ADC PARKS & GREENSPACE ARBORICULTURE

PLANNING APPLICATION: Y/50/15/HH

ADDRESS: Meadow Cottage, Hoe Lane, Flansham, PO22 8NT

BRIEF DESCRIPTION: Two storey side extension to existing cottage

Drawing
Site Plan

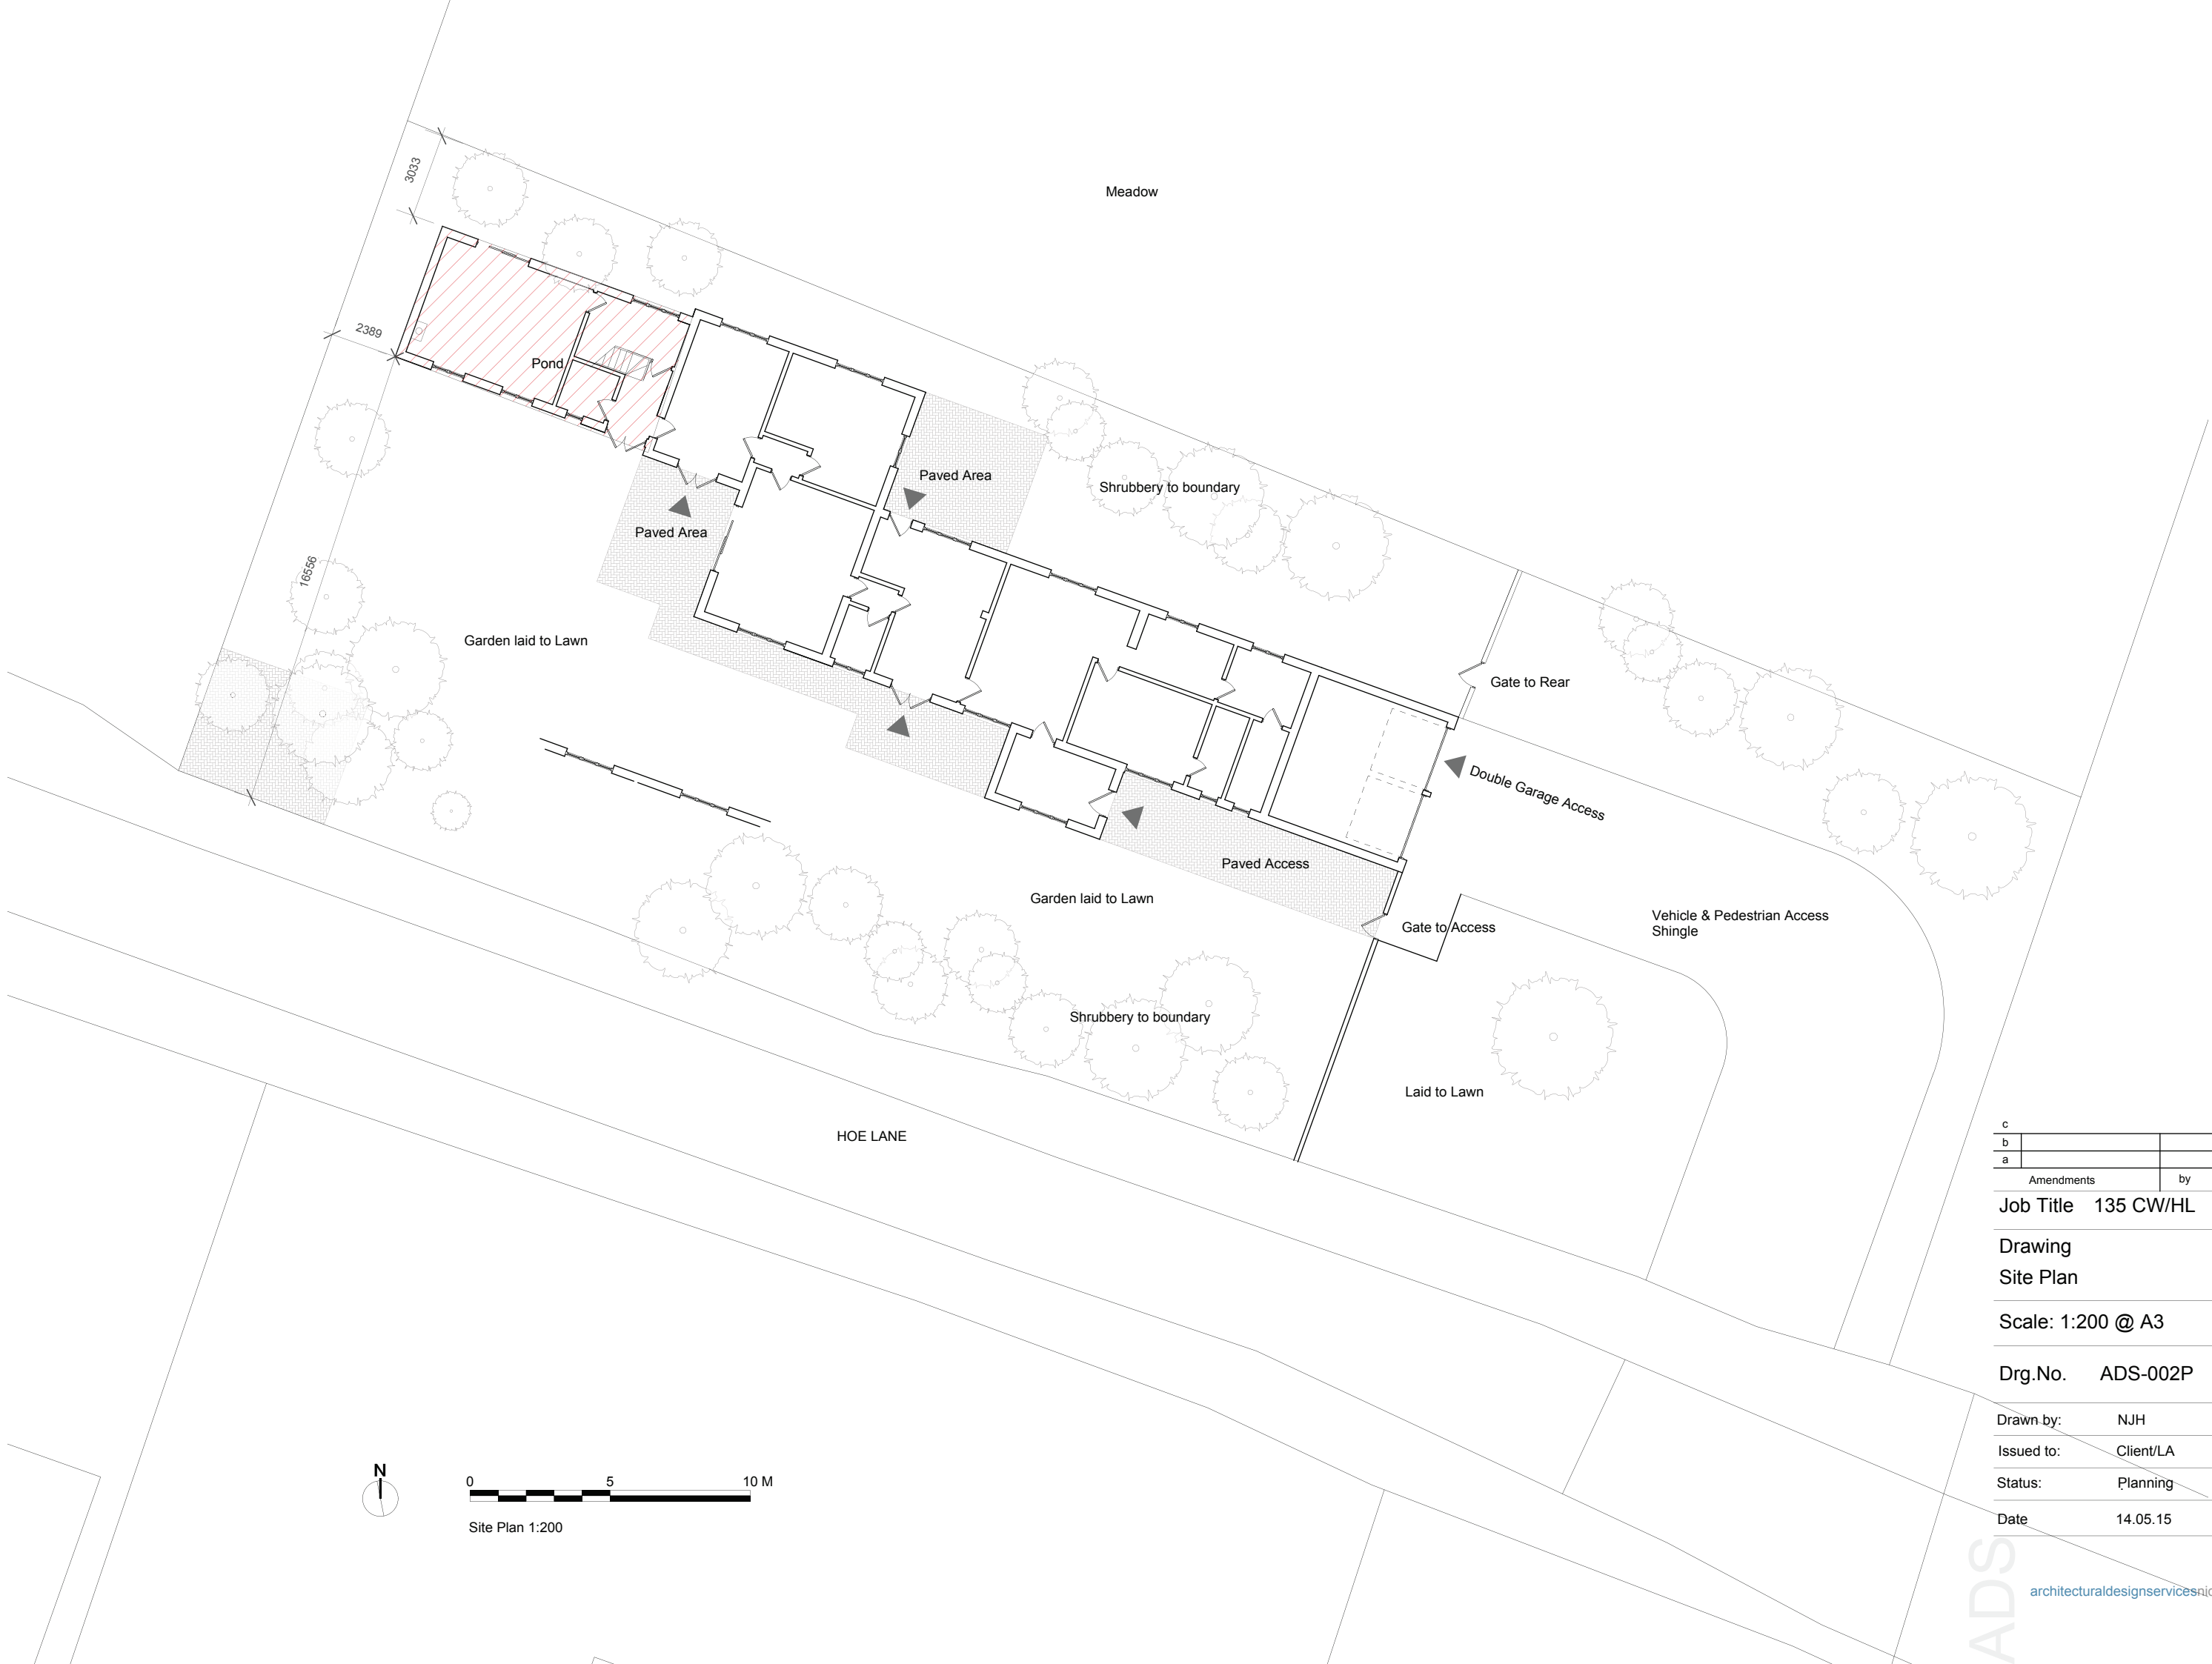
- This application refers the erection of a two story extension to the north western corner of the stated dwelling. From the submitted application this proposed extension does appear to require the removal of a number of shrubs. These shrubs are not suitable for TPO orders (due to their given stem diameters being too small to be assessed for protection). The applicant has indicated on the submitted application no intention of felling any of the established trees on site to facilitate the proposed extension.

- The other trees that may be affected by this extension are located are located in linear belt along the southern boundary of the site. From the site inspection it is clear that the established trees have had previous reductions. These reductions appear to be of a 'topping' practise – which is not an action that is undertaken currently, as it does contravene the BS 3998:2010. This practise has also devalued the aesthetic value offered by this linear belt and is also likely to have reduced the expected lifespan of these trees, as failures of major limbs is more common.

- **For the duration of this development the installation of ground protection to protect the southern belt of trees Root protection area (RPA) should be used. This ground protection is used to prevent compaction and or spillages occurring in the given RPA areas.**

- **A method statement outlying the position and type of the BS 5837 standard RPA protection is required.**
- **Once the protective measures have been installed, the Local planning authority arboricultural officer must be contacted to ensure the measures is correctly placed. This mitigation must be kept in place for the duration of the development works.**
